From: [George Wehbe](#)
To: [Simon Truong](#)
Subject: Re: Urgent objection to SSD 15_7064
Date: Tuesday, 8 December 2015 5:43:13 PM

My name is Georges Wehbe, I am the property manager of 6-8 Woodburn

Street Redfern NSW, 2016 which adjoin this proposed development.
I was asked by the owner if I received any notification regarding this proposal from planning NSW or from the City of Sydney Council and we did not. So they asked me to send you that in writing.
Please be advised that we were not notified about this application by Sydney Council or any other authority.

## Shadow diagrams - view from north

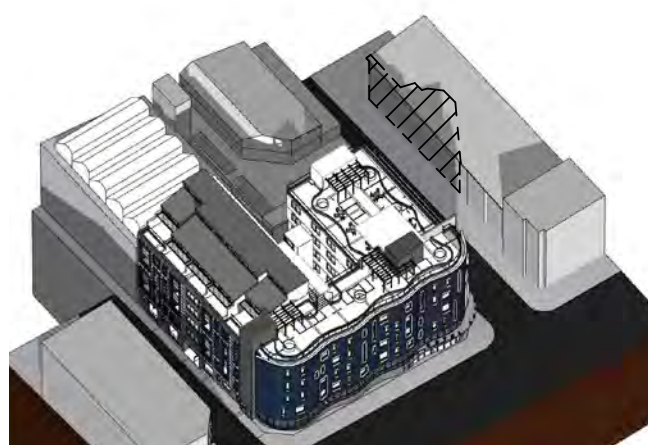
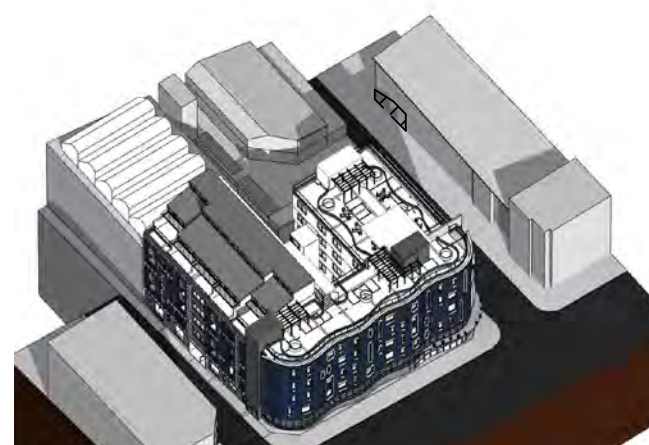
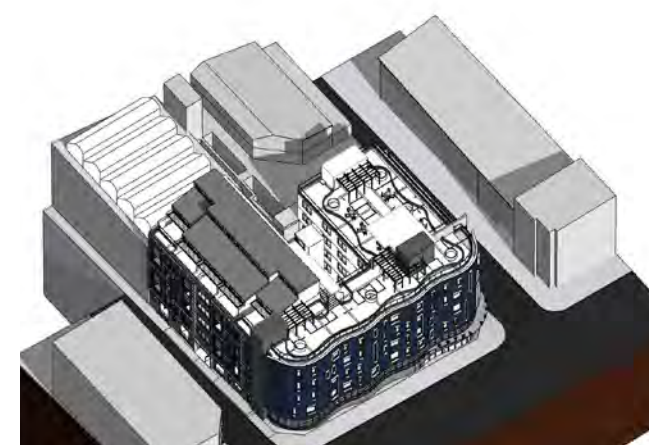
Secondly, There will be considerable overshadowing over the common area on level 3, due to the proposed 5 levels building facing Eveleigh Street.
